**Consultation Response from KC,  
Highways Development Management****2023/91272 Land Adj, 170, Penistone Road, Shelley, Huddersfield, HD8 8HZ****Erection of detached dwelling****Date Responded: 27/09/2023.****Responding Officer: D. Stainsby****Responding Ref: K12-40/25****RECOMMENDATION:**

Block Plan  
1 : 500

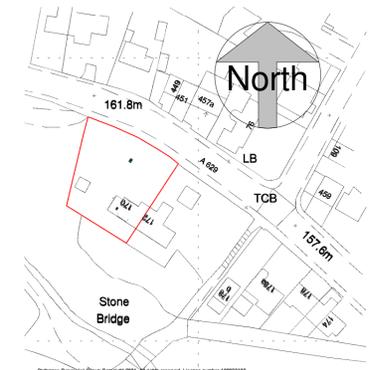
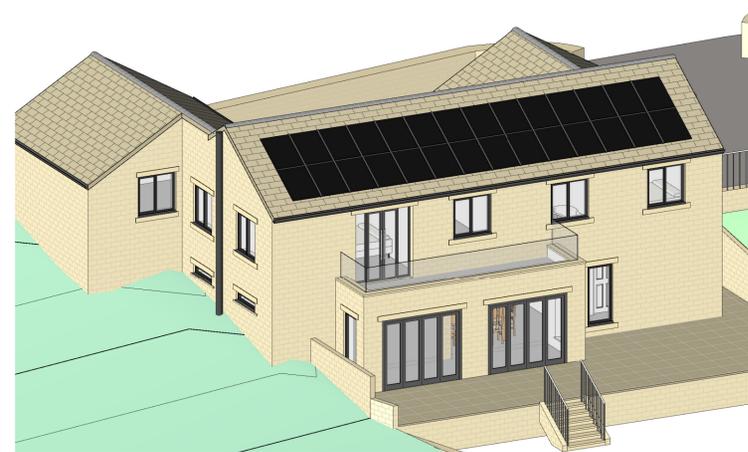
The existing access on to Penistone Road is to be widened to 5 metres wide and a level area of driveway provided for the first 6 metres into the site.

If any gates are to be proposed, these should be set back 5 metres from the edge of the adopted highway and shall be hung as to only open inwards.

Visibility splays of 2.4m x 43m are required along Penistone Road. A revised layout showing the required visibility splays should be provided to ensure that the minimum visibility can be provided for vehicles leaving the site.

A bin collection/presentation point should be located adjacent to the public highway. The bin collection/presentation point must not obstruct the adopted highway or the access road.

Details of waste storage and collection for both dwellings (existing and proposed) should be provided with the application, with the location of a waste collection/presentation point being clearly marked on a drawing in such a location that is easily accessible to the collection team and where it will not obstruct the parking, access, or the adopted highway for road safety reasons.
